Statement of Common Ground with Beverley and North Holderness Internal Drainage Board (draft)

Revision ~~23~~ (tracked)

~~September~~October 2025

- 1.1.1 This Statement of Common Ground (hereafter referred to as the 'SoCG') has been prepared to support the Examination of the Development Consent Order (DCO) application (the 'DCO Application') for Peartree Hill Solar Farm (the 'Proposed Development').

Typical access track cross section

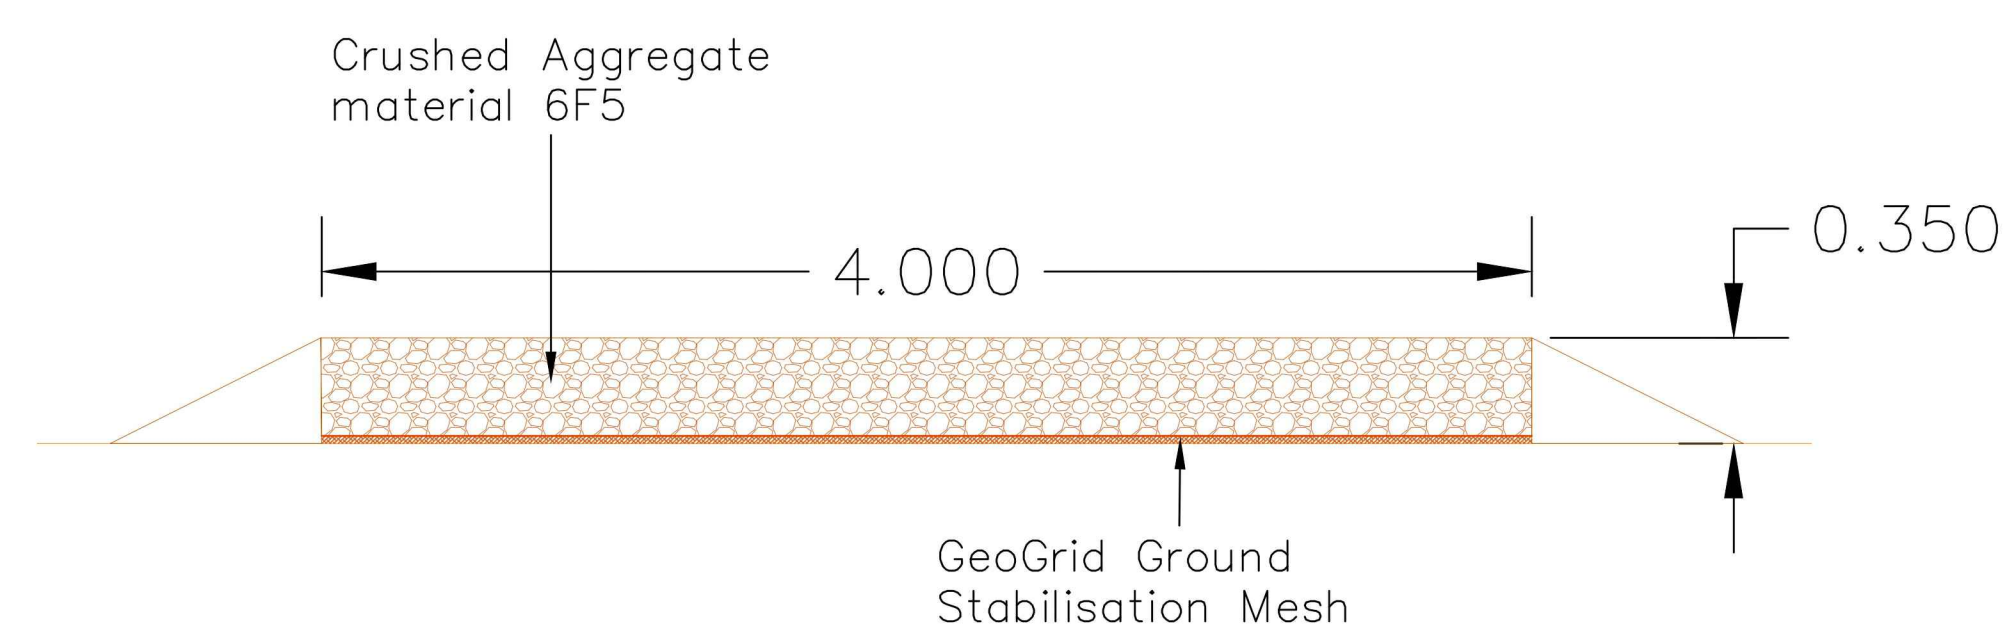
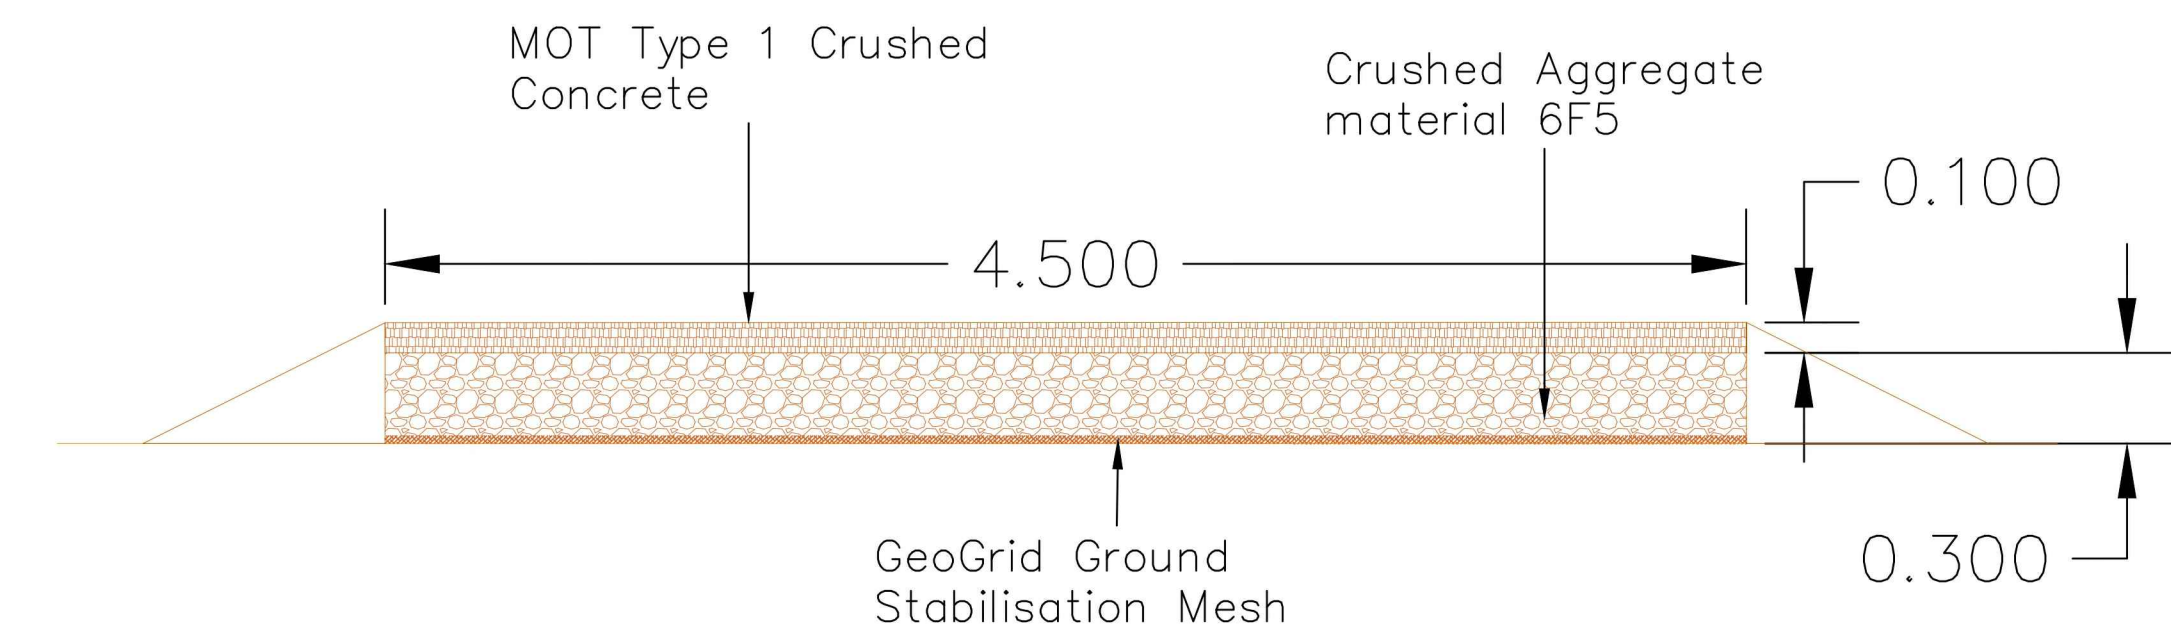
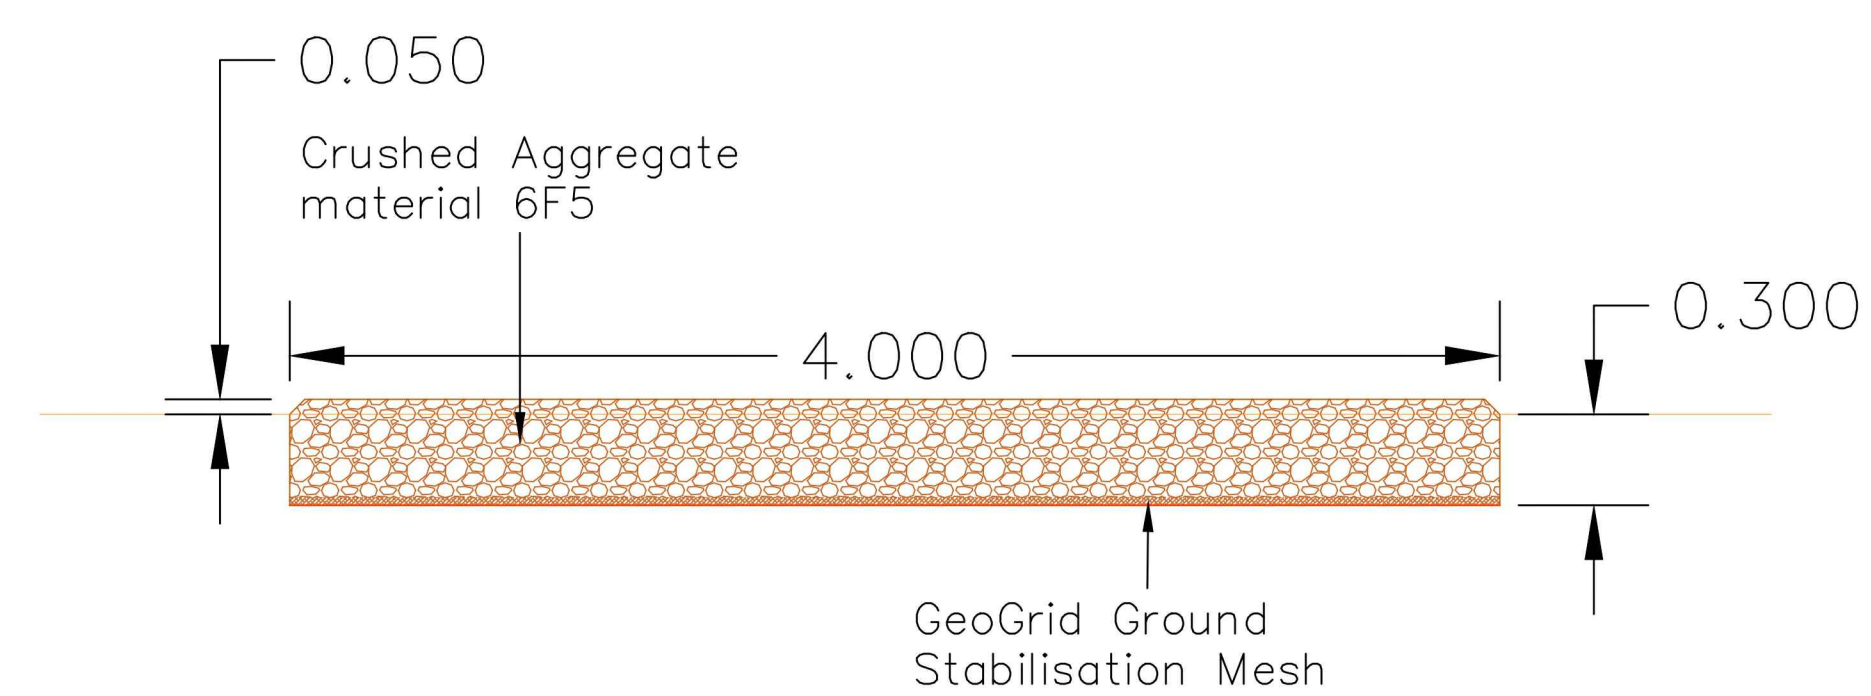
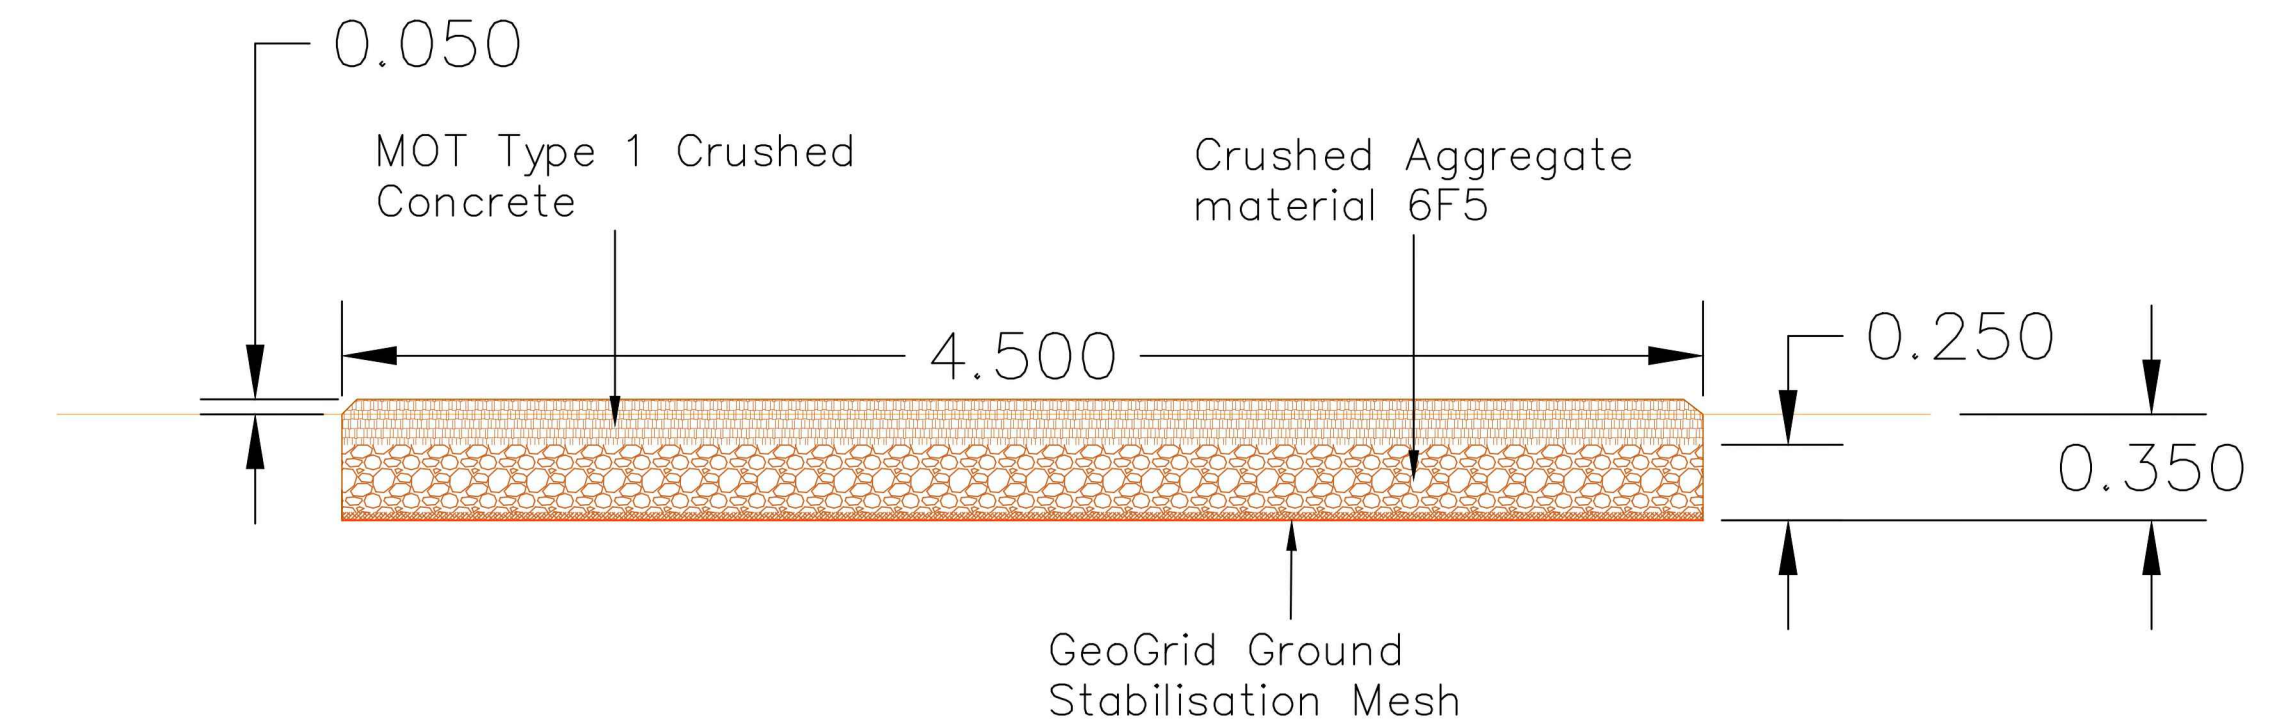
IDB02	Access tracks <i>Hydrology and Flood Risk</i>	<u>Beverley and North Holderness Internal Drainage Board confirmed via email on 29 September 2025 that it is satisfied with the Applicant's response to its</u> relevant representation [RR-004]; <u>Beverley and North Holderness Internal Drainage Board states comment</u> that if Type 3 material (with a 30% voids ratio) is used for access tracks, this is viewed as	<u>The Applicant welcomes this response.</u> Internal access track design, including materials, will be confirmed as part of the detailed design stage and submitted to East Riding of Yorkshire Council for approval as part of Requirement 3 of the Draft DCO [EN010157/APP/3.1 Revision 4] . <u>The Outline CEMP [EN010157/APP/7.2 Revision 5] has been updated to include a commitment that if Type 1 material is used for the surfacing of access tracks, the Applicant will submit a drainage</u>	<u>Under discussion</u> <u>Agreed</u>

Ref	Topic	Beverley and North Holderness Internal Drainage Board Position	Applicant's Position	Status
		"permeable" and not requiring a drainage strategy-, whereas if Type 1 materials or other impermeable materials are used, this is viewed as "impermeable" and requiring a drainage strategy.	strategy for the relevant works to the Beverley and North Holderness Internal Drainage Board. The updated document is submitted at Deadline 3. The Applicant will continue to liaise with the Board on this matter.	
IDB03	Bridge/ culvert crossings over watercourses <i>Hydrology and Flood Risk</i>	In its relevant representation [RR-004], Beverley and North Holderness Internal Drainage Board requests that details of any bridge/culvert crossings over any watercourses within its district will need to be discussed and agreed with the Board.	<p>The Applicant agrees to this request. It is the Applicant's intention to utilise existing culvert crossings and/or bridge structures where possible. Pre-construction structural surveys will be undertaken to determine the most appropriate crossing at each location (it is expected that the pre-construction surveys would result in the number of new crossings required to be lower than is shown on ES Volume 3, Figure 3.6: Indicative Culvert Crossing Points [APP-060]). Crossing design would be controlled by the protective provisions within Part 3 of Schedule 12 to the Draft DCO [EN010157/APP/3.1 Revision 4], which require plans to be submitted to the Board for approval at the detailed design stage.</p> <p>ES Volume 4, Appendix 5.6: Flood Risk Assessment [EN010157/APP/6.4 Revision 3] and ES Volume 4, Appendix 5.5: Water Framework Directive Screening and Scoping</p>	Agreed
